April 28, 2006

**Subject: Office Renovation Review
Portland Water District
Portland, Maine**

Thank for choosing E.S. Coffin Engineering & Surveying, Inc. to perform a review of the proposed plans for the office renovation at the Portland Water District located in Portland, Maine. The following review is based on the proposed plans provided by Choice Design and structural plans of the existing building provided by Ganneston Construction.

(C) Indicates Areas to be Carpeted

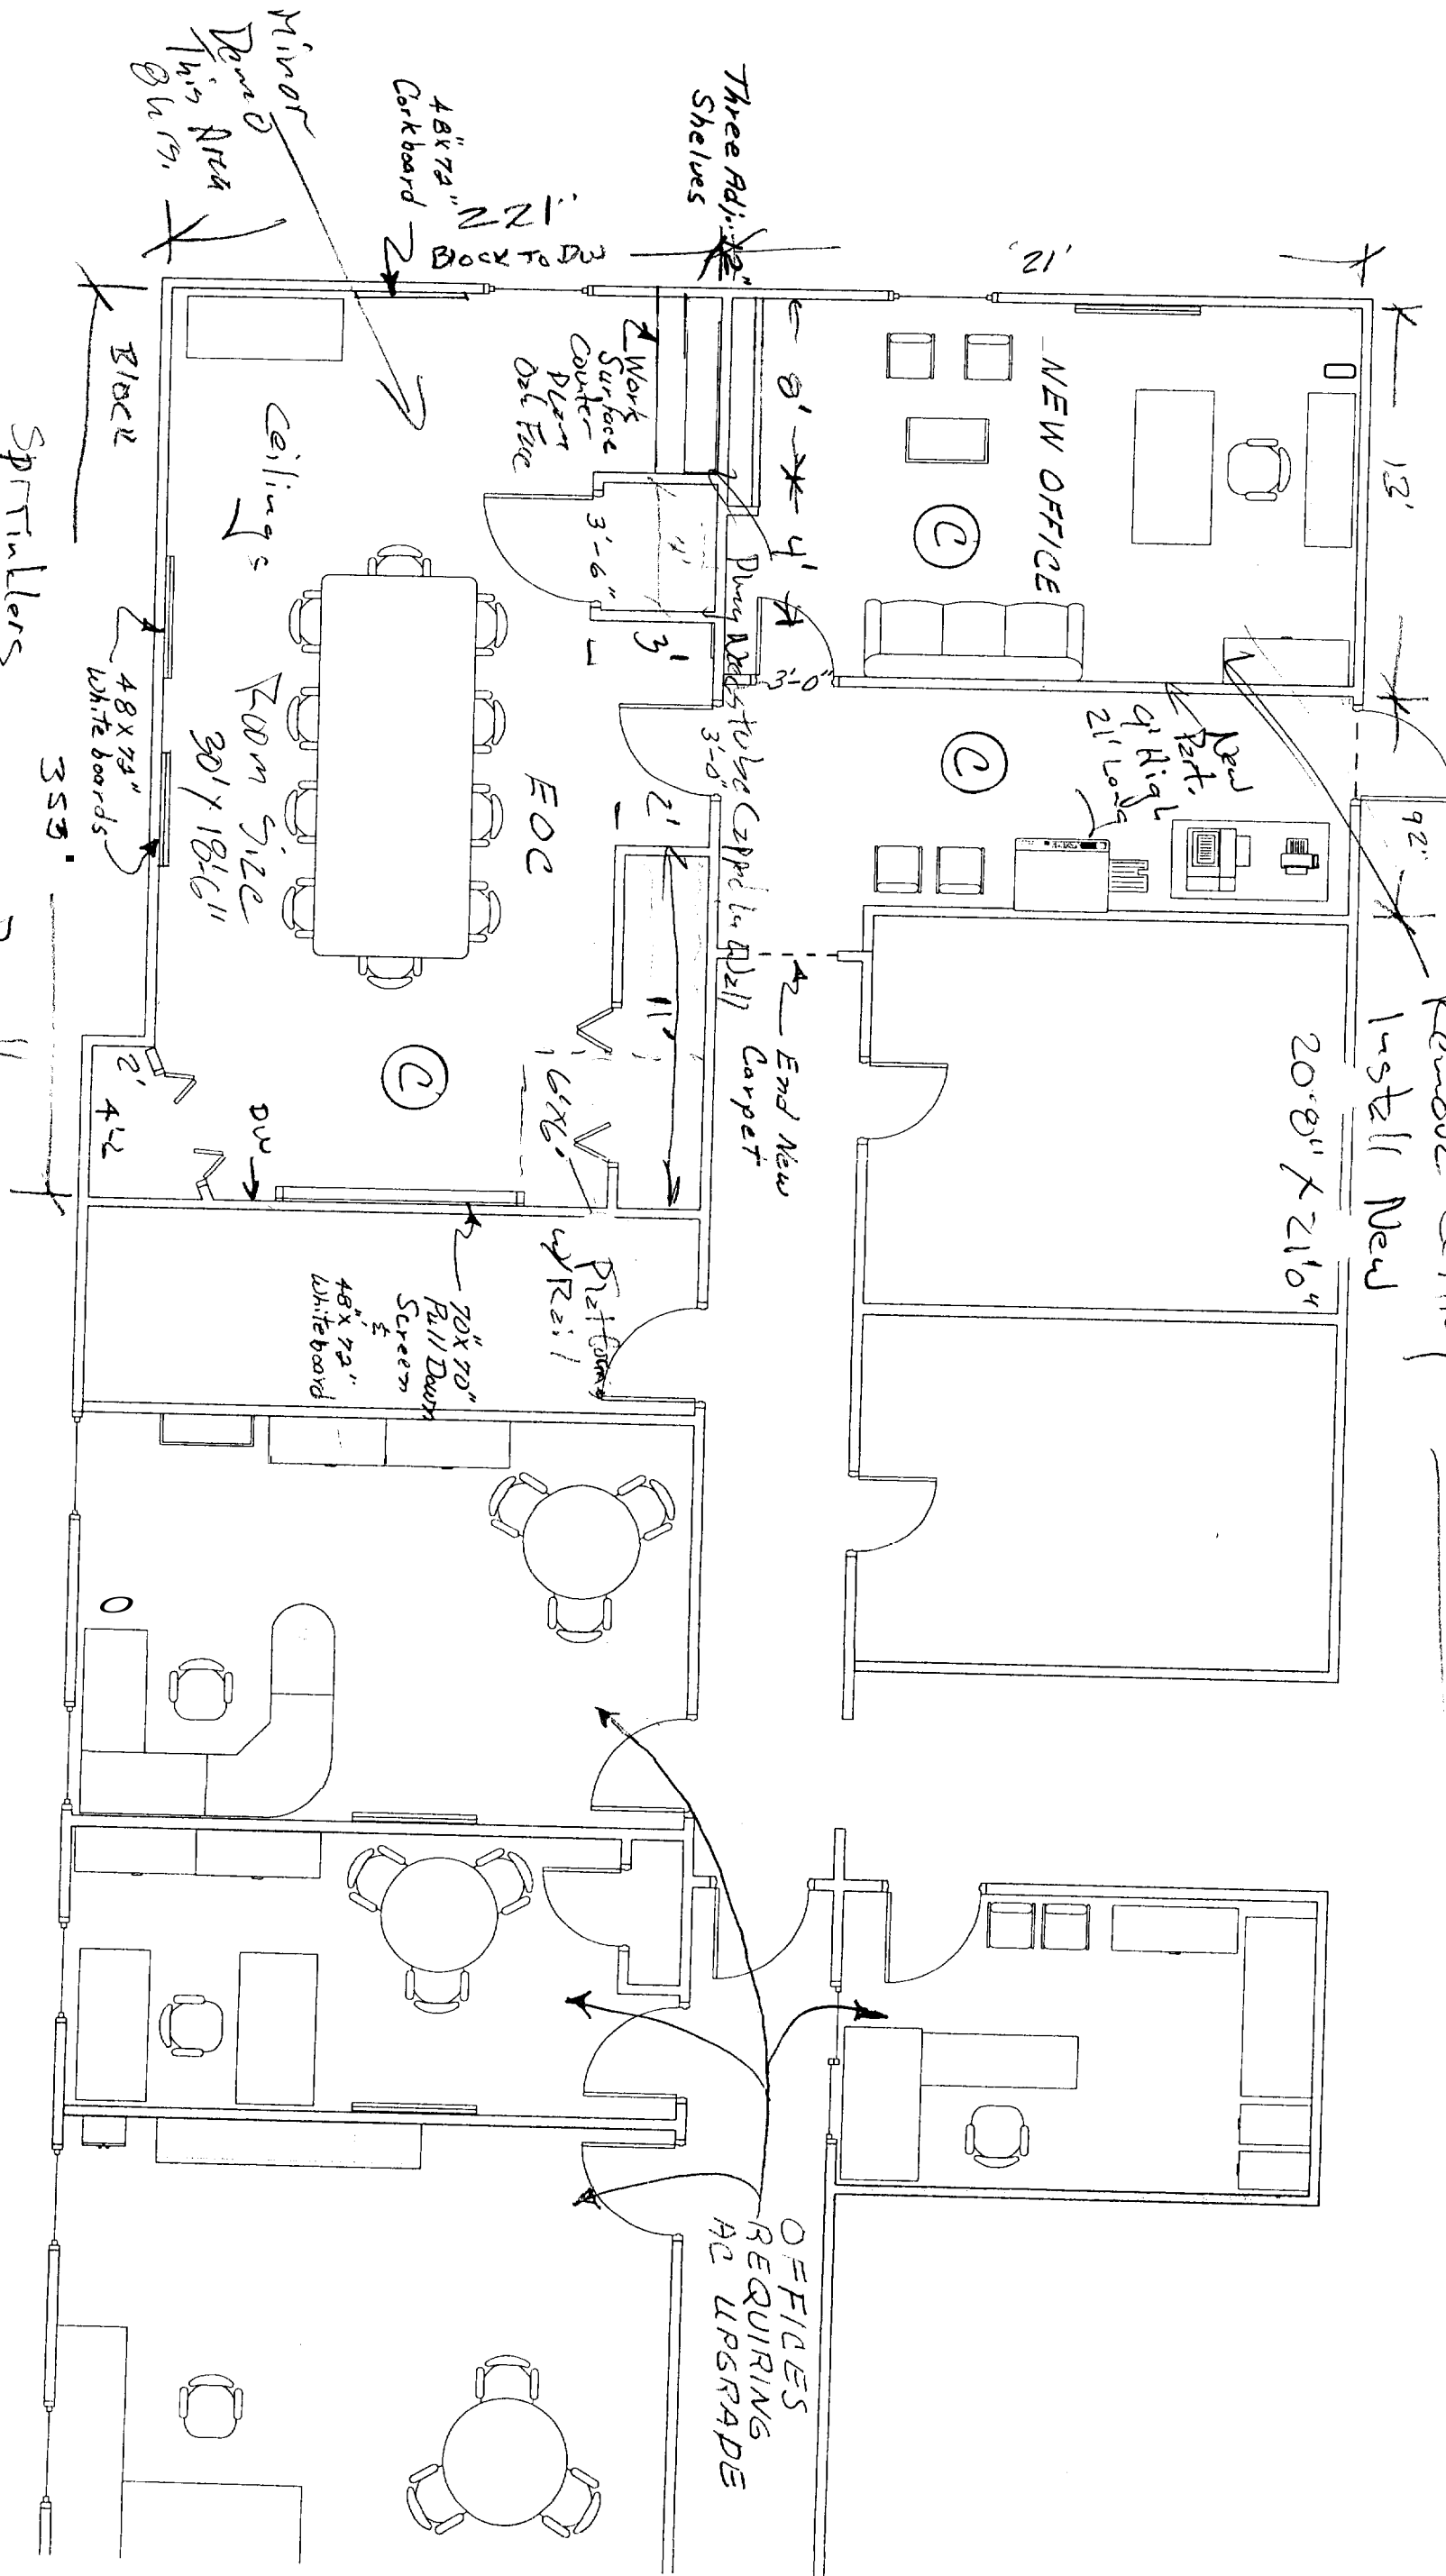
A review of the proposed plans found that the renovation on the first and second floor do not restrict egress paths or create dead end corridors in reference to the requirements of the NFPA Life Safety Code. We recommend that emergency lighting be installed in the hallway on the first floor along the back wall. Emergency lighting also needs to be installed on the second floor hallway to illuminate the existing egress door at the end of the hallway. We also recommend that the closet in the conference room be shortened in order to allow for a minimum of 18" clear on the pull side of the door into the conference room. This review is based on the partial drawings provided. We have not conducted a full Life Safety Code or **ADA** review of the building.

Once the plans have been revised to show the changes described above, we will stamp the plans for submission to the City of Portland. If you have any questions, please feel free to call me at 623-9475.

LOC & NEW OFFICE  
SECOND FLOOR

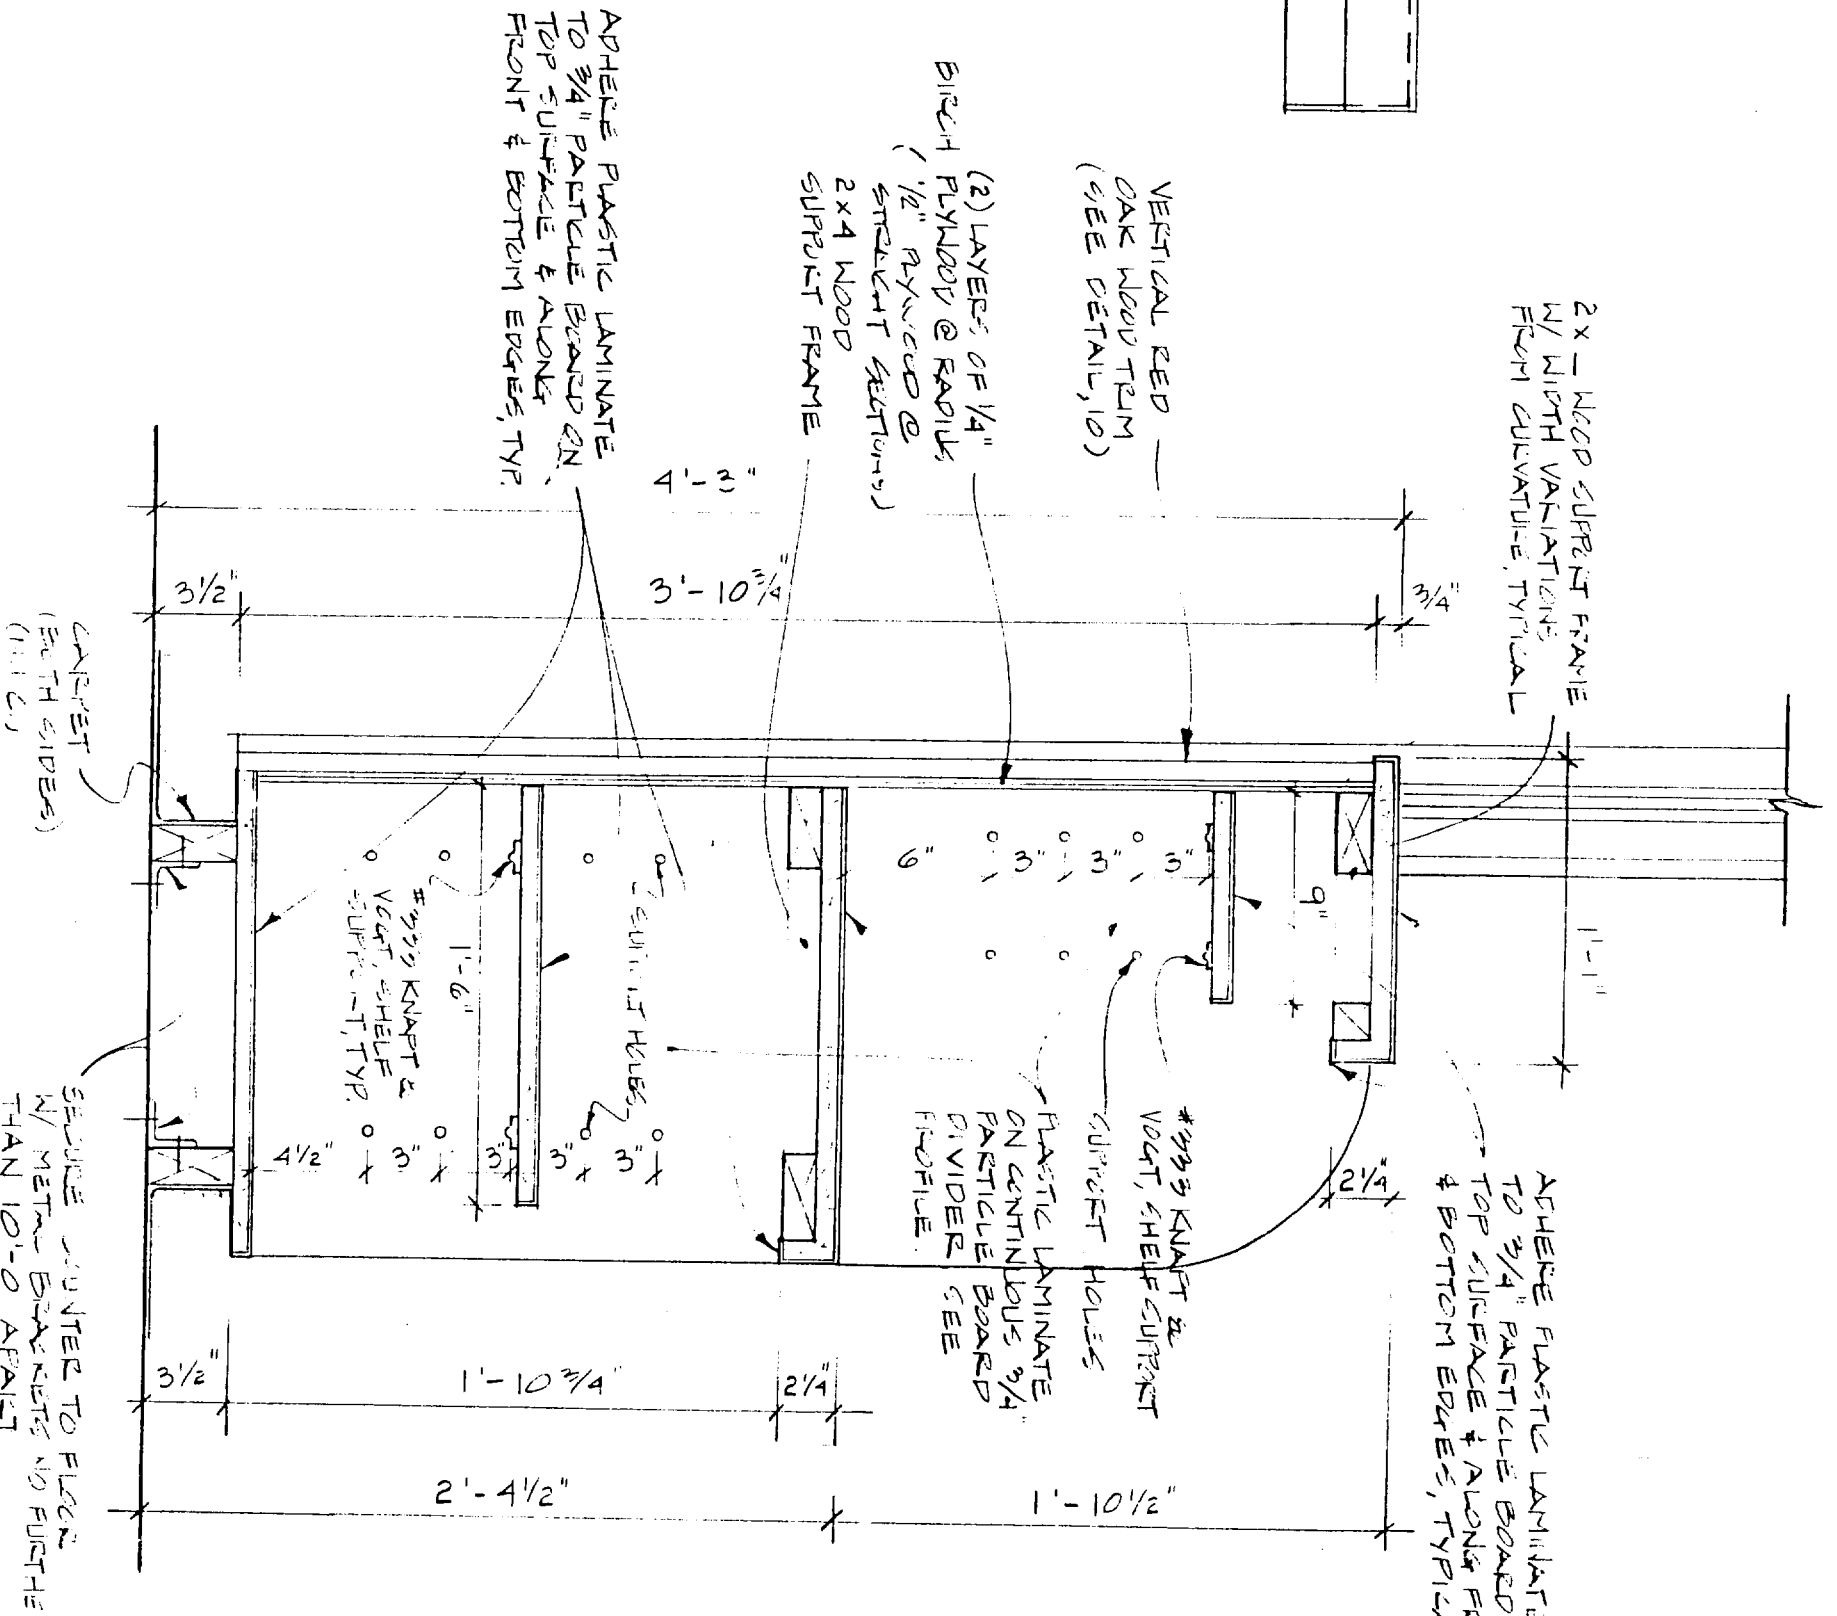
The current usage of the first floor is office space, which is the same as the proposed renovation usage therefore a review of the structural framing is not needed in this area. The renovation on the second floor is a change of usage from storage to assembly use. We have conducted a review of the existing structural drawings and found that the framing in this area is designed to support the required loading for an assembly use. This review is based on the floor framing being in good condition with no structural defects or damage. We have limited our review to the second floor and drawings provided only.
